DRB Application No.: 04DRB-00024 (SBP)
Project Name: EAST END ADDITION
Agent: TIERRA WEST LLC

DEVELOPMENT REVIEW BOARD TRANSPORTATION DEVELOPMENT Standard Comment Sheet

DRB- 1002714 Item No. 7 Zone Atlas J-19

TO: Sheran Matson, DRB Chair
FROM: Juanita Vigil, Planner
SUBJECT: Project # 1002714 Zangara Dodge

ENGINEER'S SEAL RONALD R. BOHANNAN P.E. #7868	ZANGARA USED CAR LOT	DRAWN BY: B/JF
	SITE PLAN FOR BUILDING PERMIT	DATE: 12/30/03
	TIERRA WEST, LLC 8509 JEFFERSON NE ALBUQUERQUE, NEW MEXICO 87113 (505)858-3100	23105SPB-12-30-03x
		SHEET # C1
		JOB # 230105

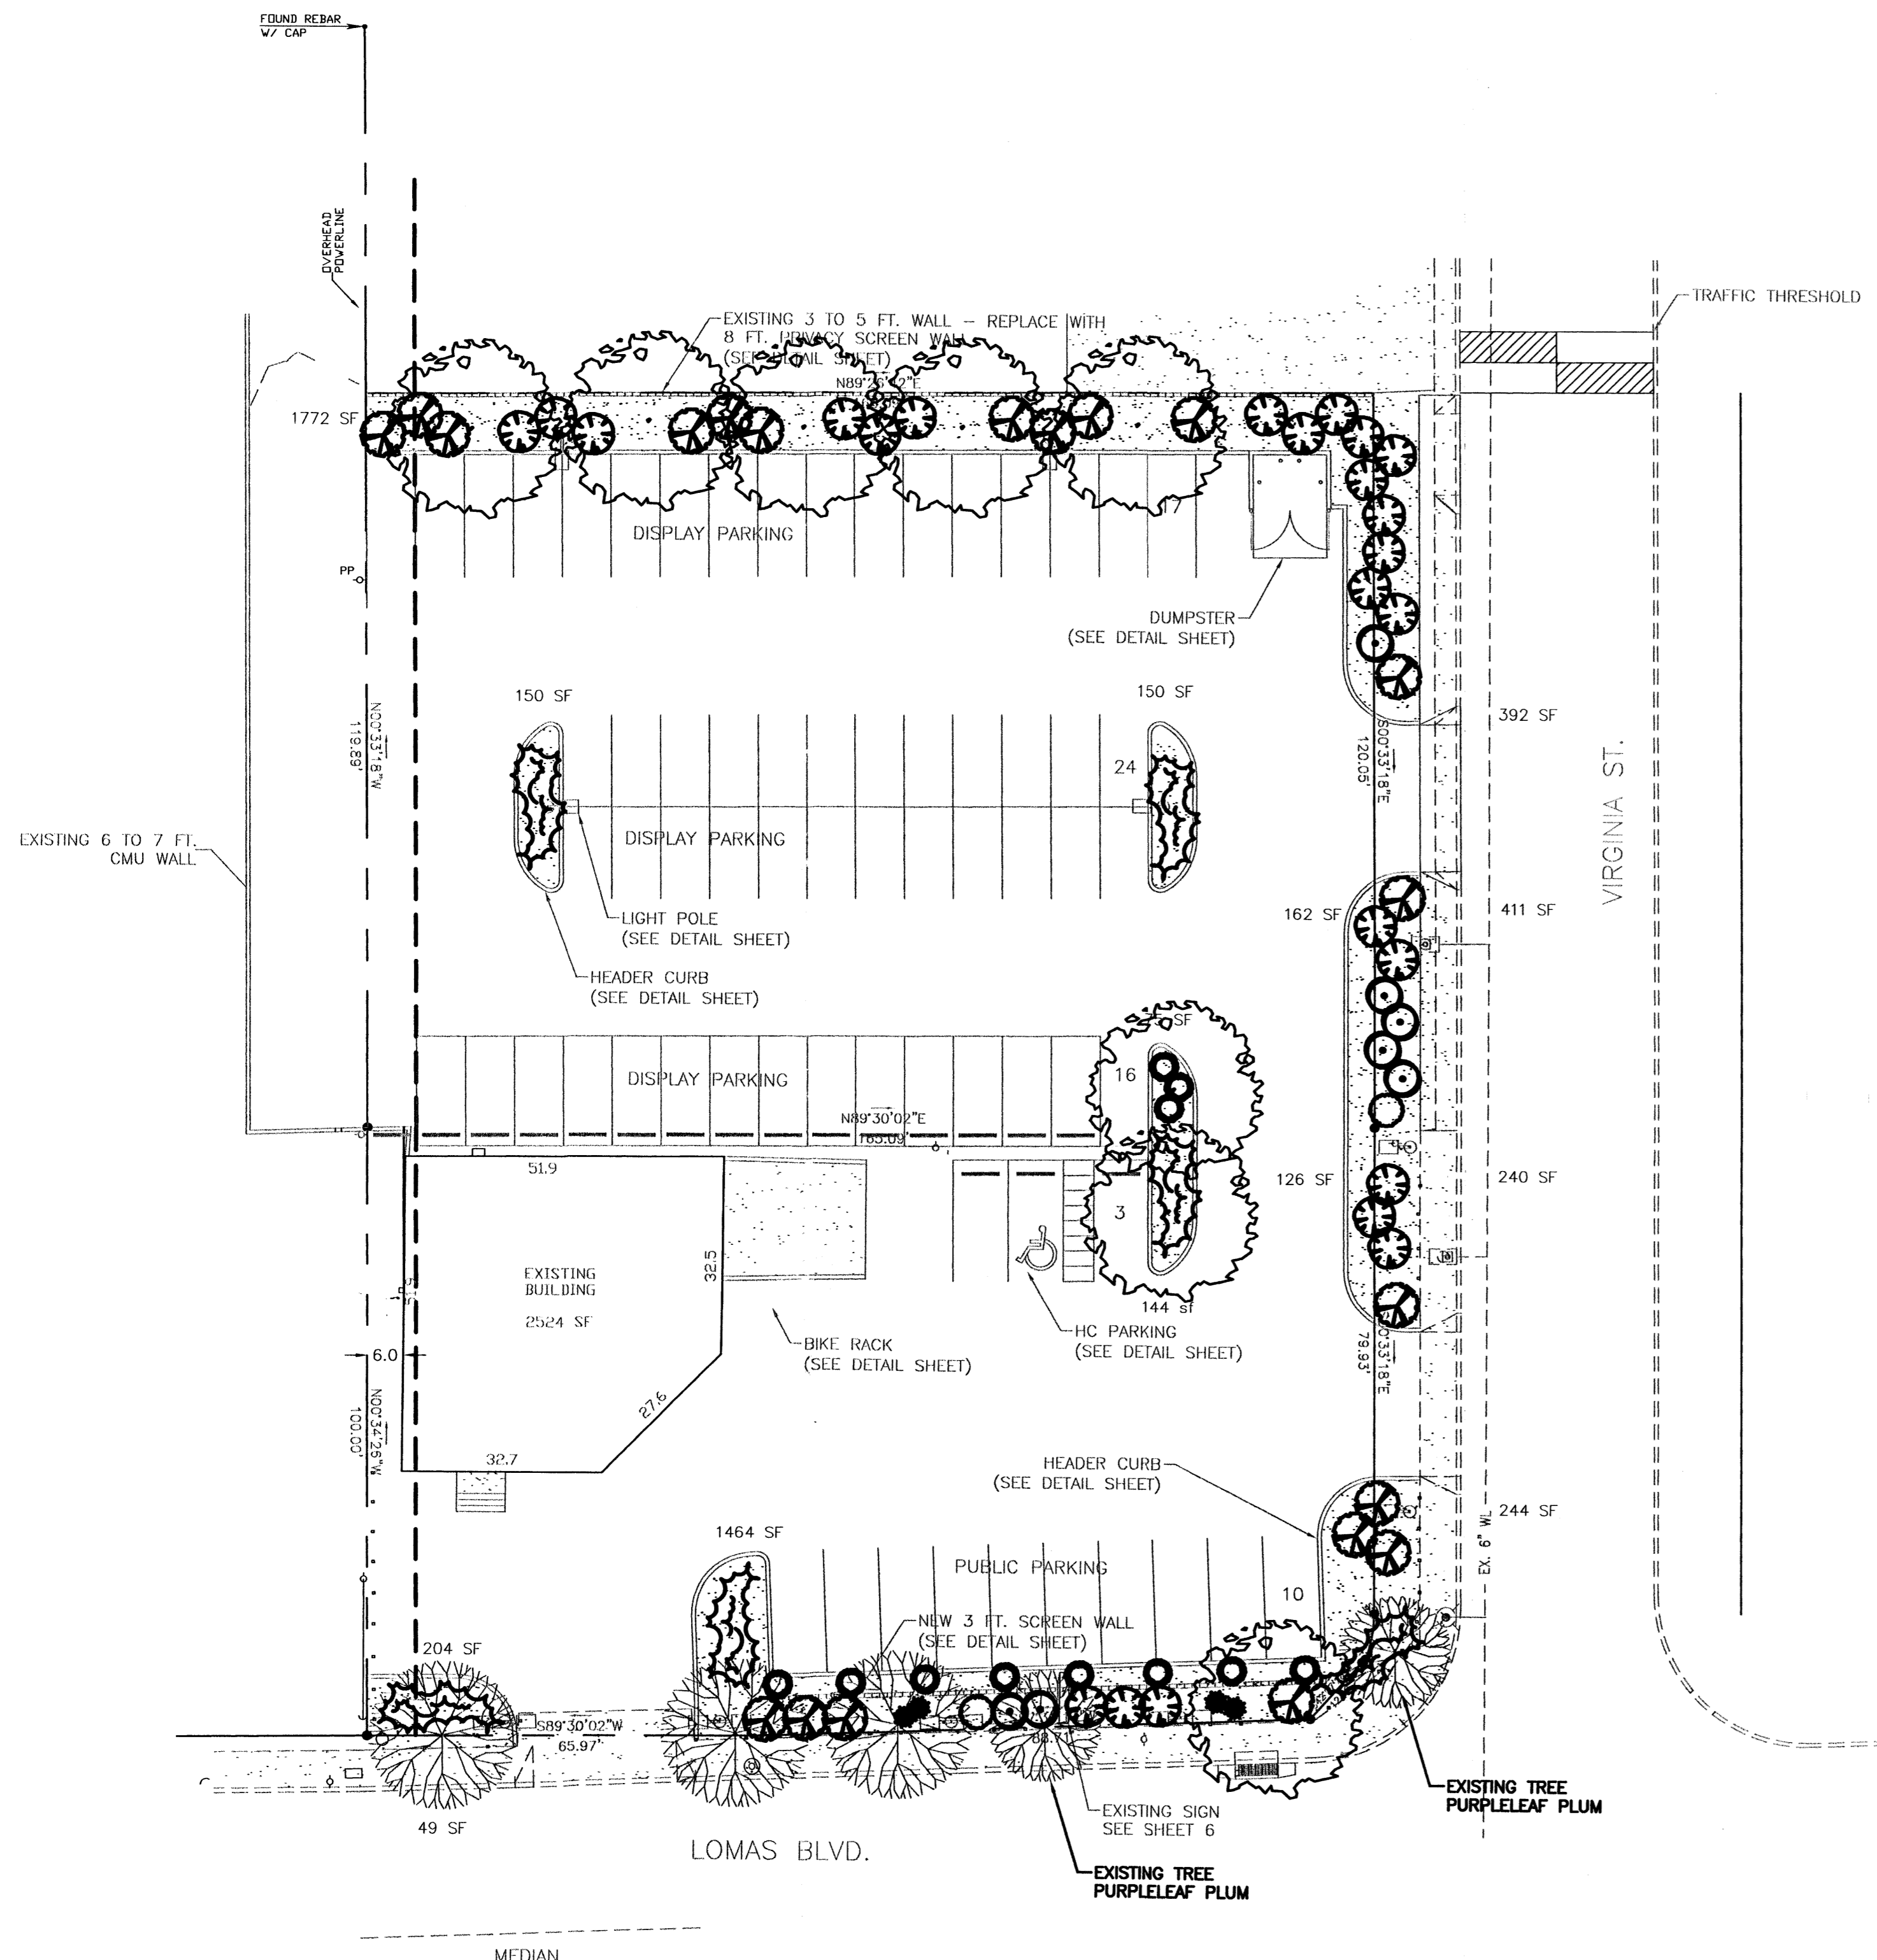
No.	Comment
	- SITE PLAN PLAN SHOULD IDENTIFY THE THE WIDTH OF PUBLIC RIGHT-OF-WAY REQUIRES DRL PLANS / DRIVE CROWN
	OR
	ITEMS SHOULD BE IDENTIFIED BY CITY STANDARD
	- TYPICAL RADIUS IS 15' @ ISLANDS
	- NEED ADA DETAIL FOR DRIVE PAD
